MARIST COLLEGE NORTH SHORE REDEVELOPMENT PLANS

Would you please answer the following questions in relation to your design:

Drawing No. DA-101	Issue C
Scale 1 : 200	Drawing Size A1
Project No. 18165	Drawn By SL/BE

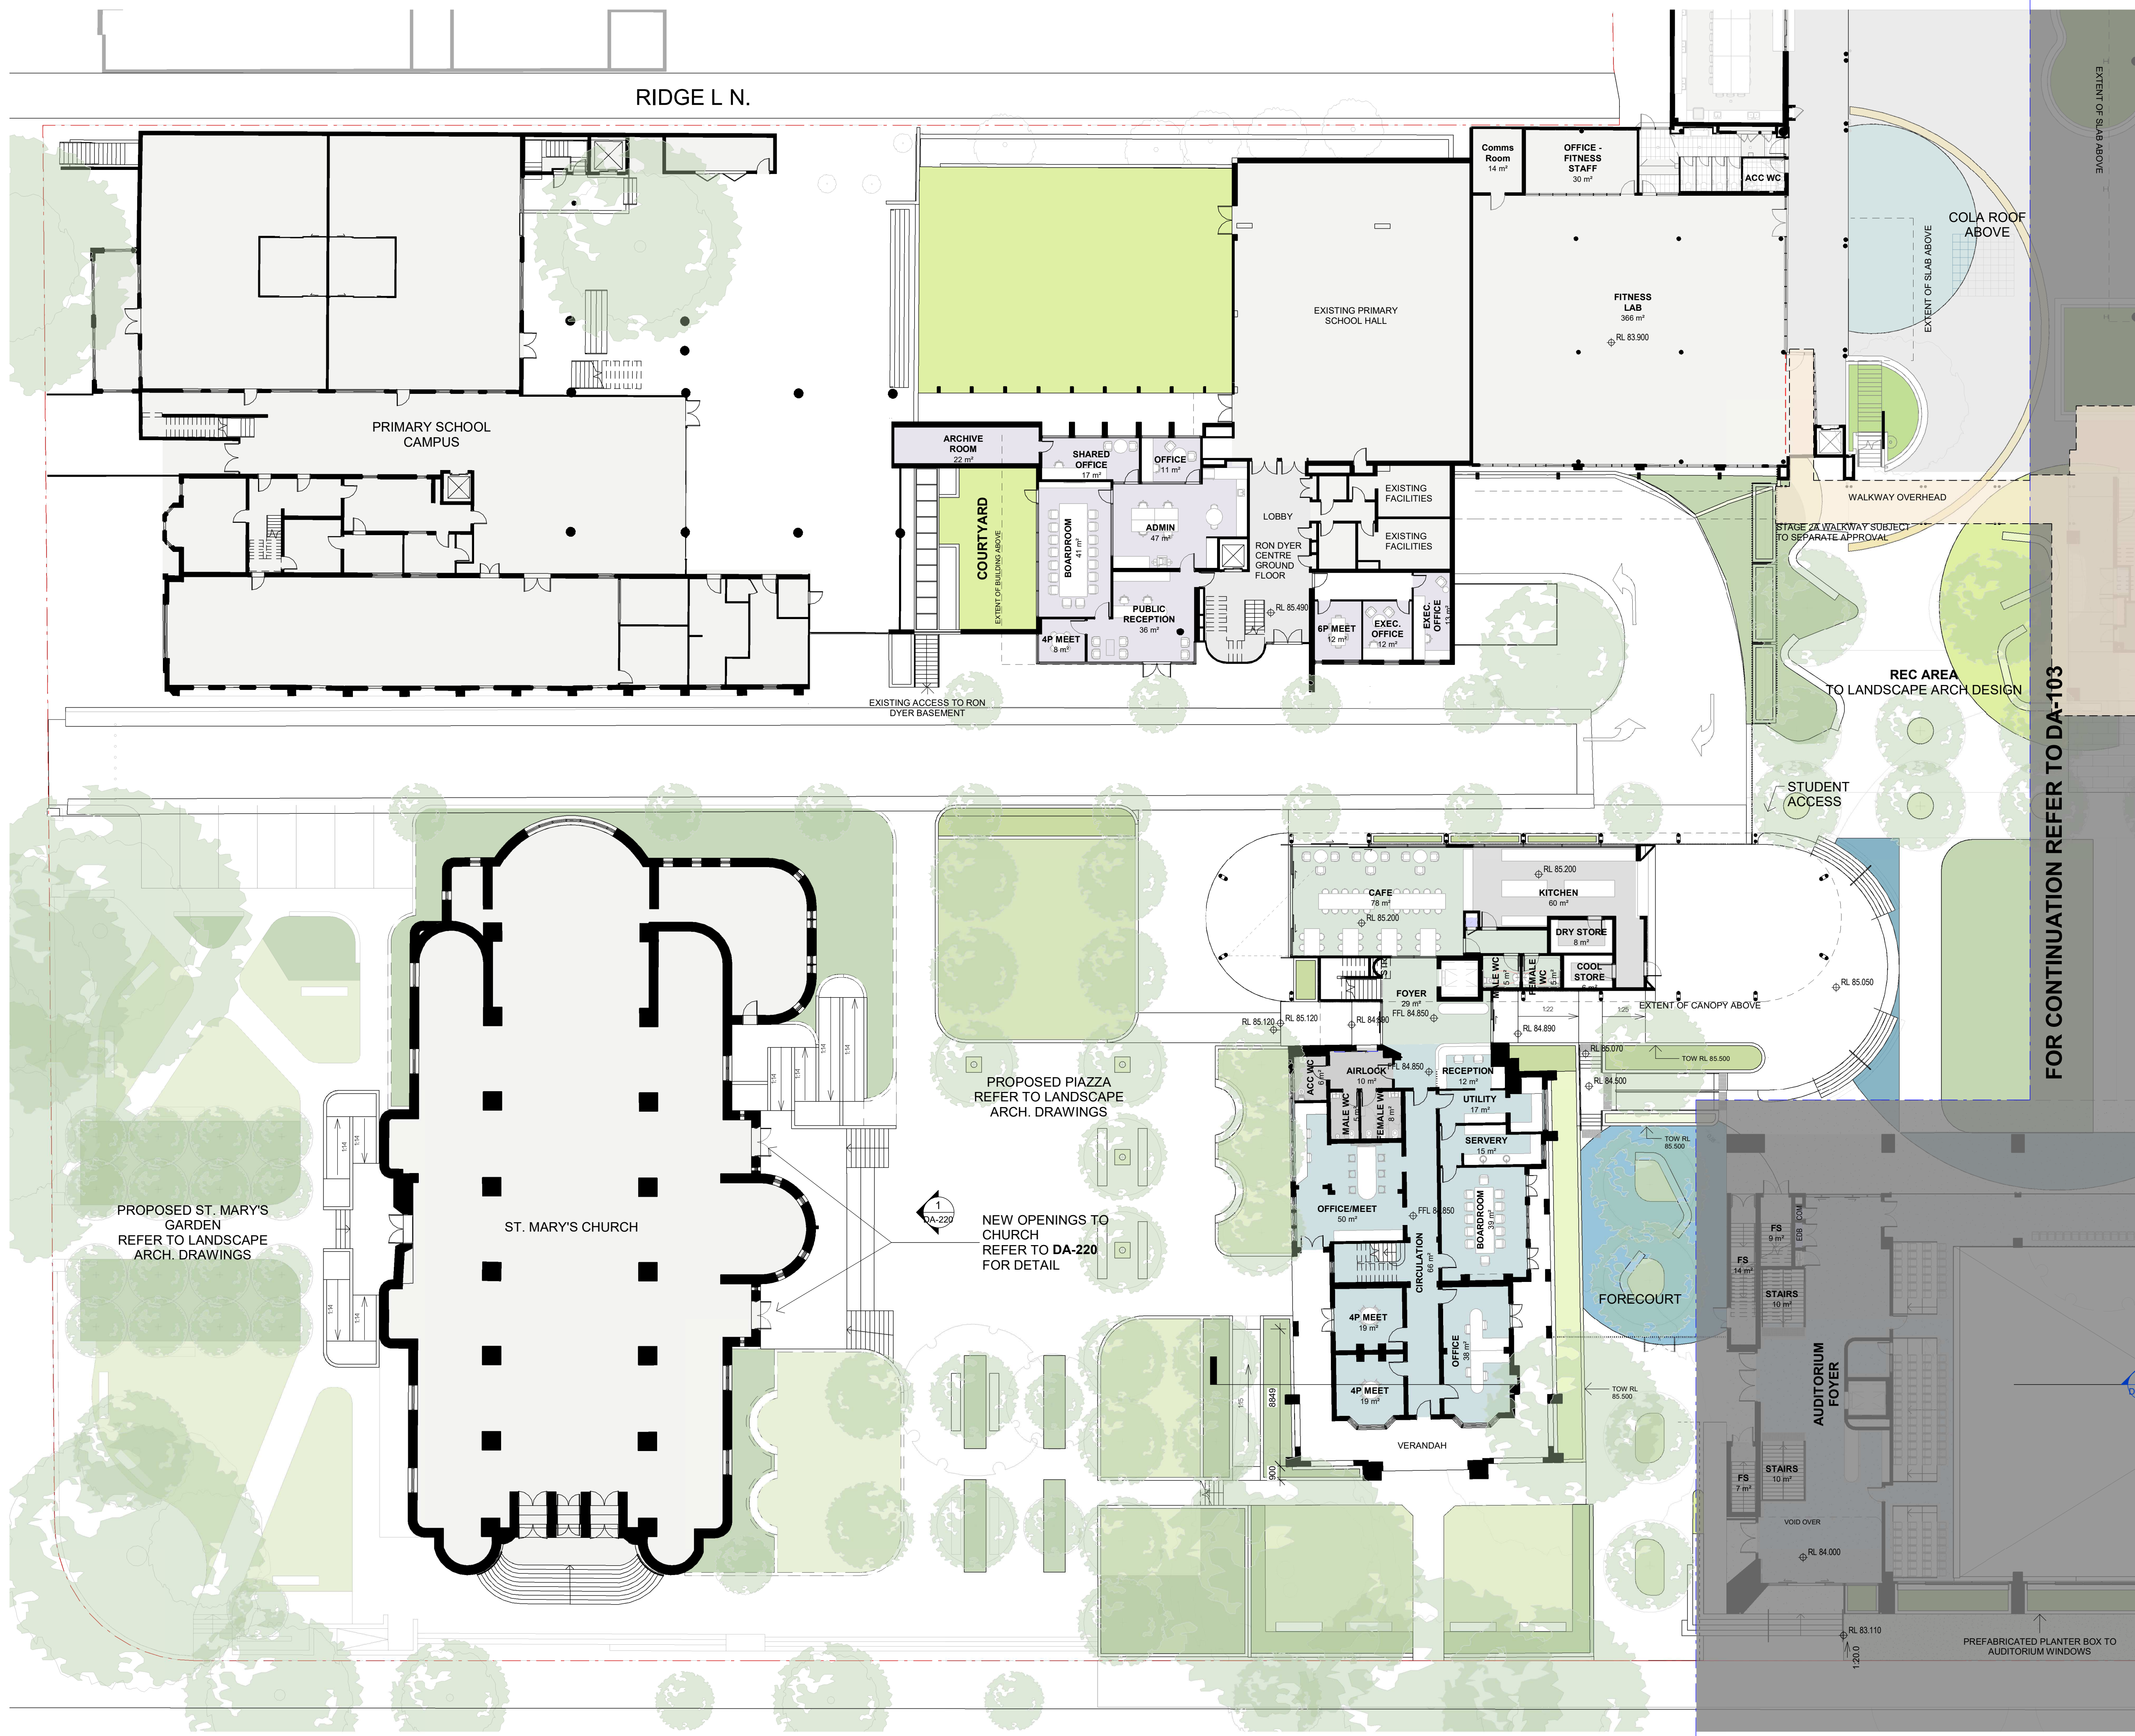
- 4. Have you proposed that cars travelling east on Carlow Street be prevented from turning right into the car park ramp to go under the building?** As a single two way access to the proposed northern underground carpark under the proposed four storey school building is only from Carlow Street, cars travelling east on Carlow Street must be prevented from turning right into the carpark ramp to prevent street traffic congestion. A centre road barrier would be essential as residents of Carlow Street will never be able to move during school drop off and school pickup times. Carlow Street traffic is now very congested and slow during morning and afternoon school entry/exit hours with the current 1200 number of students, which is significantly below the future 2000 proposed number!

5. **Will there be a timed “drop-off zone” in Miller Street instead of the existing car parking now available along Miller Street?** The existing two car entry / exits from Miller Street are proposed to be removed. There are proposed pedestrian entries shown on plan from Miller Street to the Child Care and Auditorium!

Drawing No. DA-102	Issue C
Scale 1: 200	Drawing Size A1
Project No. 18165	Drawn By SL/BE

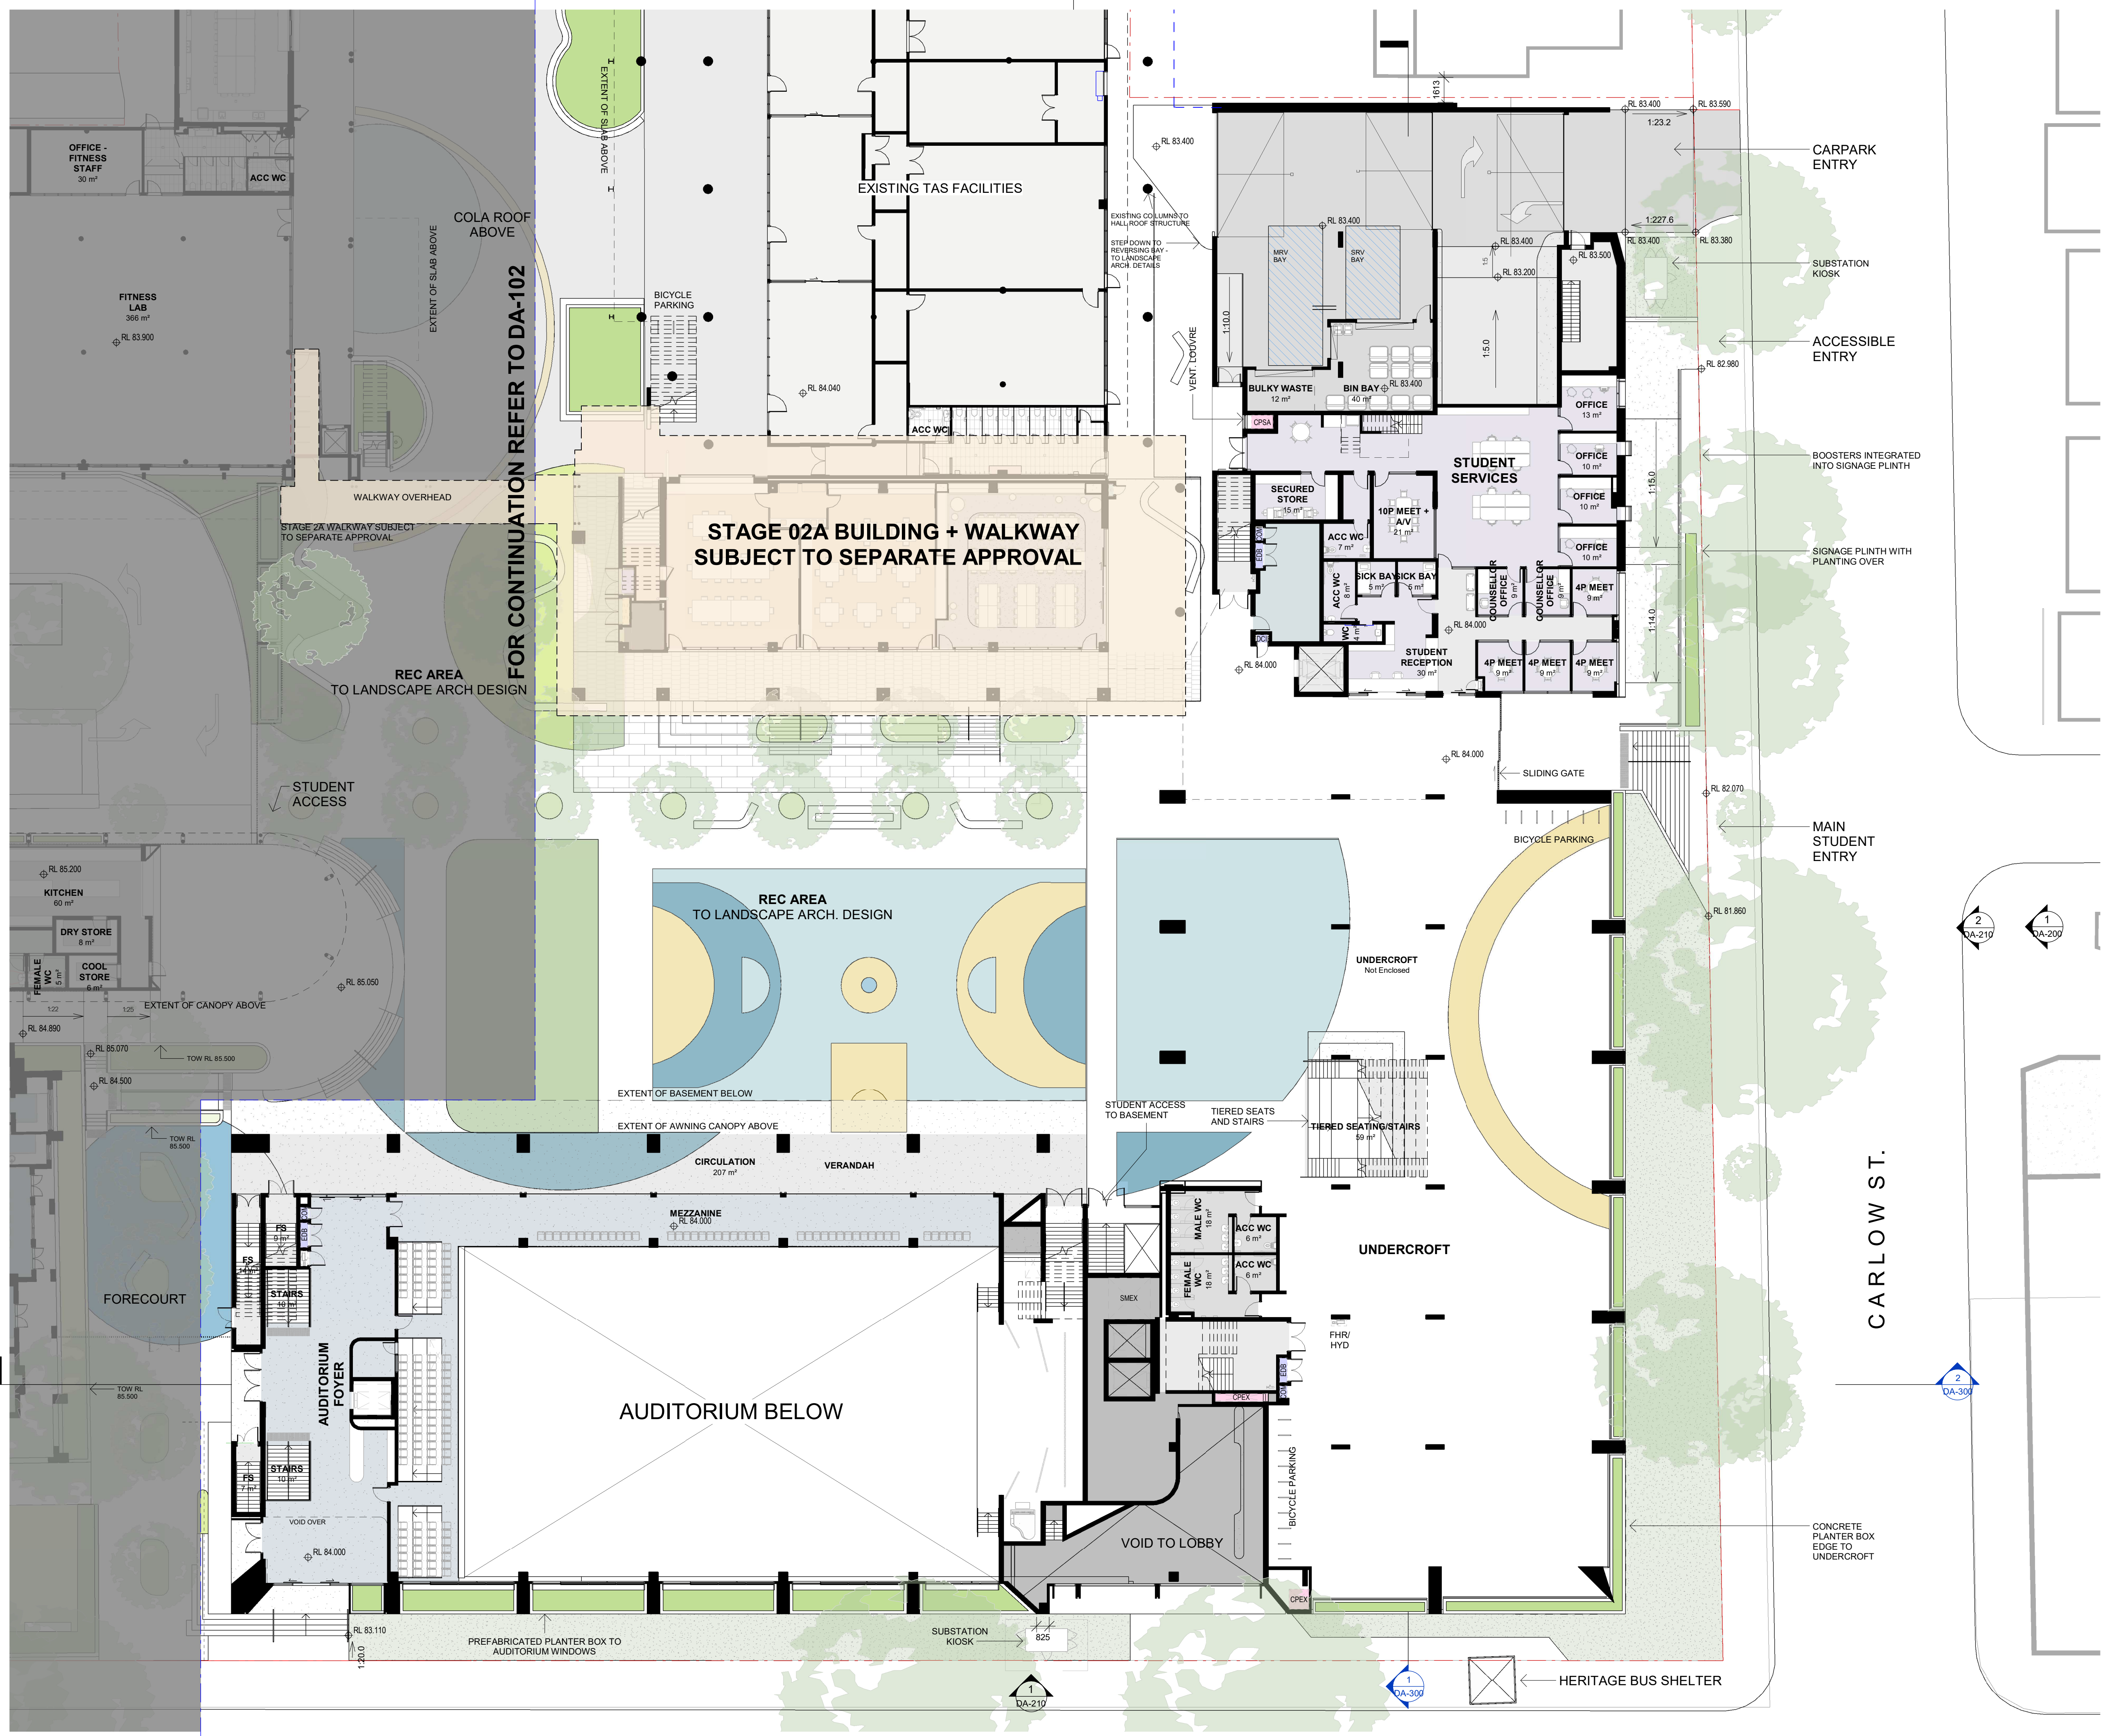
- 2. Why is some existing parking located north of the Church not retained at ground level and a carpark completely constructed under the proposed "Piazza" having its entry/exit from the existing road from Ridge Street?** It is worth noting the example by Ku-ring-gai Council which is currently constructing a ground level "Piazza" with car parking below in Lindfield to meet forward projections and provide public recreation space. Such a redesign will also assist the proposed School Auditorium entry foyer operation, as it will need substantial car parking due to its seating capacity of 1528 seats!

1 CARLOW ST ELEVATION

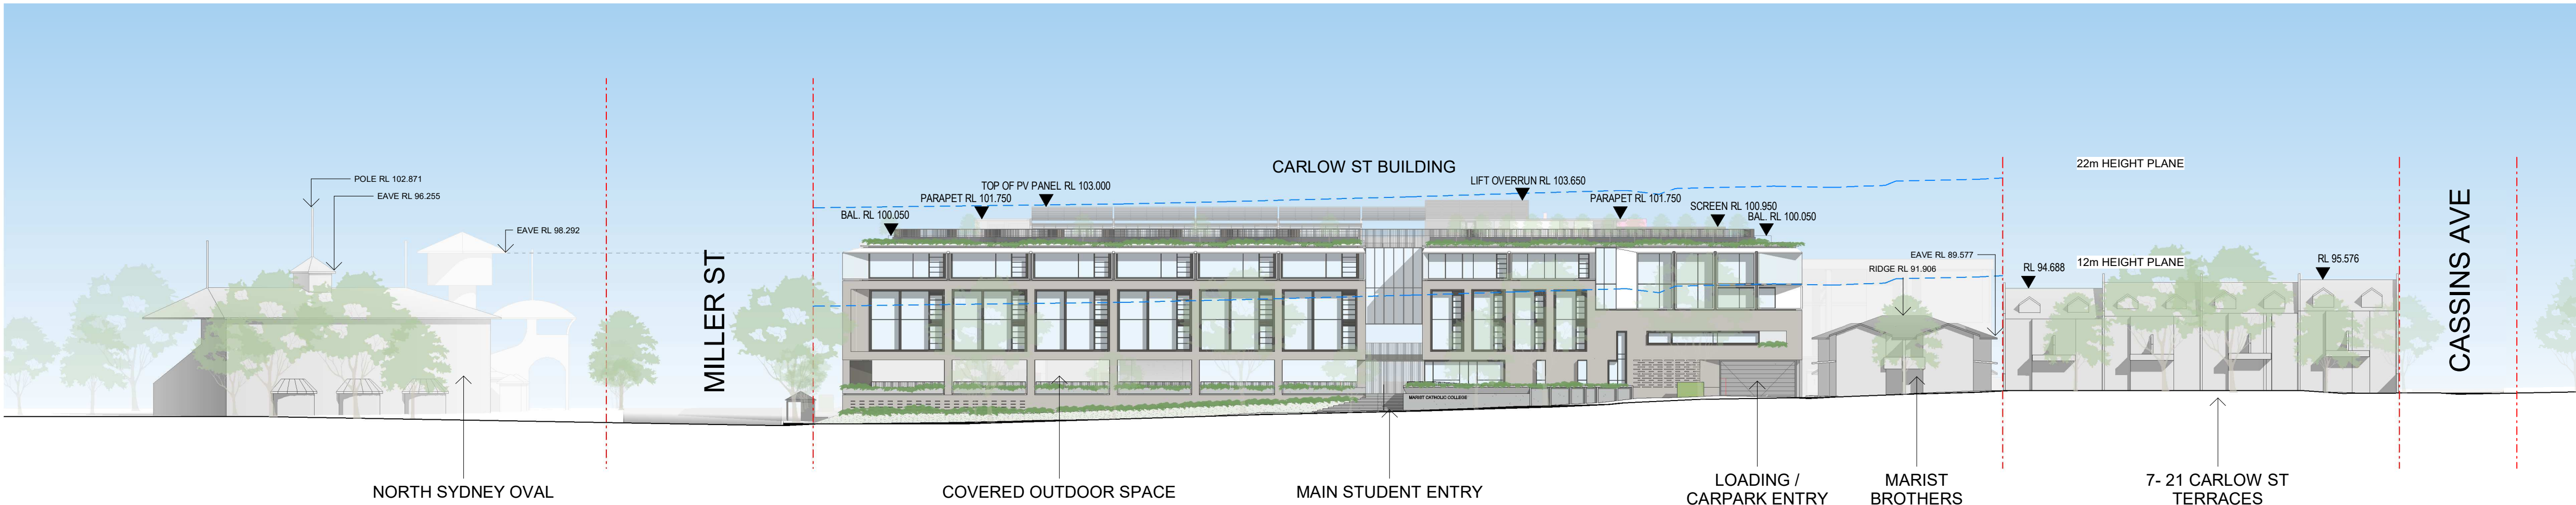
6. **Why is the building setback from Carlow Street not 6300mm minimum for the whole length of the proposed building due to its substantial design building height?** This should not be reduced in the westerly direction to 4400mm in order that landscaping area not be lost. Residents do not want to lose the character of this Conservation Area!
